# CITY OF ALBUQUERQUE

**Re: C and D Land Corp (Phase I)**  
**411 Wyoming SE**  
**Traffic Circulation Layout**  
Engineer's Stamp 09-17-2020 (L19-D023)

Based upon the information provided in your submittal received 10-28-2020, the above referenced plan cannot be approved for Building Permit until the following comments are addressed:

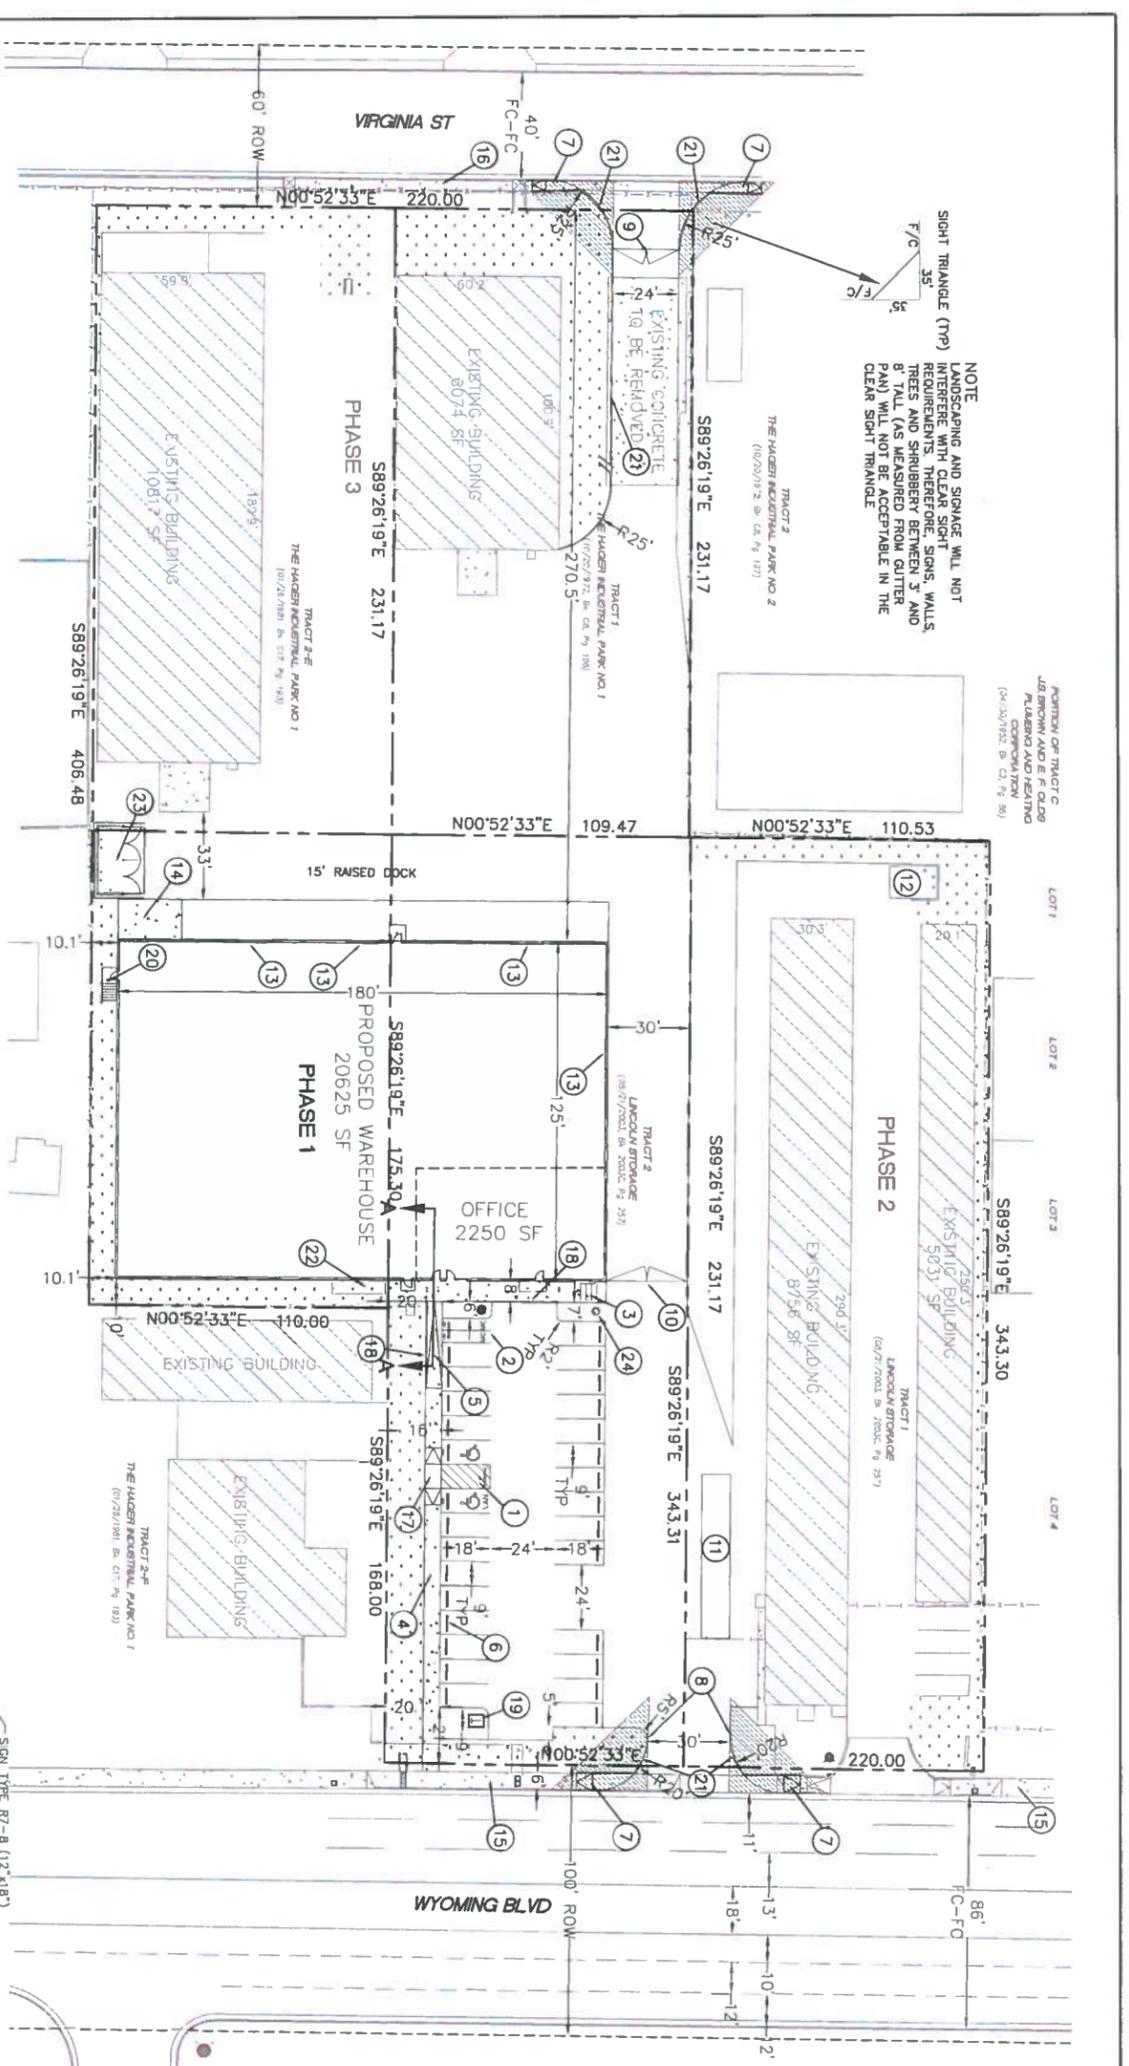
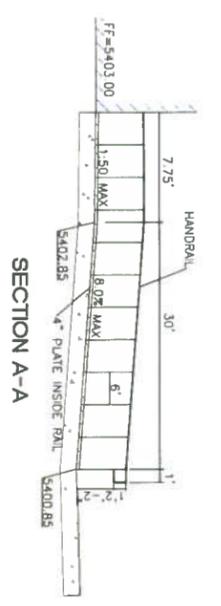
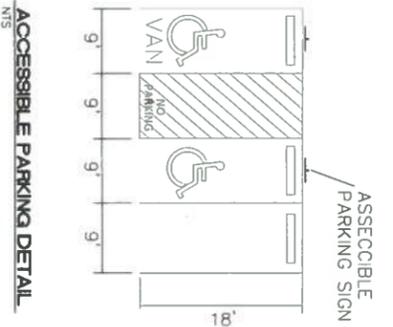
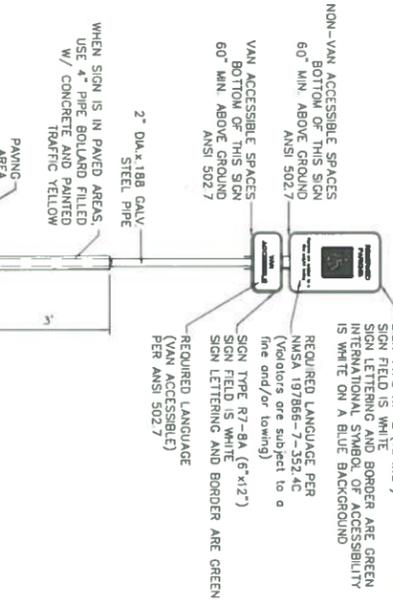
1. The listed number of parking spaces required by the zoning code as well as the proposed number of parking spaces including bicycle and motorcycle parking. All proposed required calculations need to be discussed with Zoning.
2. Wyoming Blvd: provide existing sidewalk frontage.
3. Identify all existing access easements and rights of way width dimensions.
4. Identify the **right of way width**, medians, curb cuts, and street widths on Wyoming Blvd.
5. Clarify existing property lines and proposed property lines. Is there an approved plat? If so please provide.
6. Maximum access width for **arterial (Wyoming)**, collector, and local streets are as follows, **Need to explain why you are proposing a 64 ft wide driveway, the driveway needs to have curb returns:**

7. Extending the driveways in front of the building portions will be a safety concern and the existing portion of driveway is not ADA compliant. This will need to be addressed. All driveways need to be ADA compliant. **Suggest combining driveways into one functioning access if possible (DISCUSSION).**

8. Please provide a clean sheet for proposed drive aisle and drivepad extension. It is very confusing to determine what is being proposed since existing infrastructure has not been removed on site plan. Will you need to provide turning templates to show that a vehicle and/or delivery vehicle can tranverse around the parking stall without encroaching onto the driving bumpers on the 90 degree turn from the street (**Existing building to be remove is the site drive aisle in question**)
9. You will need a certain throat depth off Wyoming prior to locating the proposed parking stall. Please review DPM to verify that you comply with the minimum set back/throat depth based on commercial footage.
10. Please list the width and length for all proposed parking spaces. Some dimensions are not shown.
11. The minimum parking stall dimensions are:

12. Provide proposed sidewalk detail on site.
13. ADA curb ramps must be updated to current standards and have truncated domes installed (**Wyoming frontage**).
14. Show all drive aisle widths and radii. Some dimensions are not shown.
15. The minimum drive aisle dimensions are shown below (**IF applicable**)

16. List radii for all curves shown; for passenger vehicles. Radius for delivery trucks, fire trucks, etc. is 25 ft. or larger(**if applicable to the operation of the site**).
17. A 5 ft. keyway is required for dead-end parking aisles.
18. Provide a copy of refuse approval (**if applicable to the site function**).

19. Keyed note 7: A detail will need to be provided for the proposed 32 ft ramp with handrail.
20. Keyed note 2 needs to have a reference to **sheet DET-1** for its details.

21. Keyed note 1 & 3 reference sheets (**DET-1 & SP-1**) for overall details.
22. Keyed note 17 (**Sheet DET-1**): the slope can be a **12:1 max** instead of 15:1.

23. The proposed 6ft sidewalk connection from public sidewalk might have a conflict with the existing/proposed driveway (**ADA safety concern**).
24. Please specify the City Standard Drawing Number when applicable (**driveways, sidewalks**).

26. Unused curb cuts must be replaced with sidewalk and curb & gutter. A build note must be provided referring to the appropriate City Standard drawing.

27. Add a note stating "All broken or cracked sidewalk must be replaced with sidewalk and curb & gutter." A build note must be provided referring to the appropriate City Standard drawing.
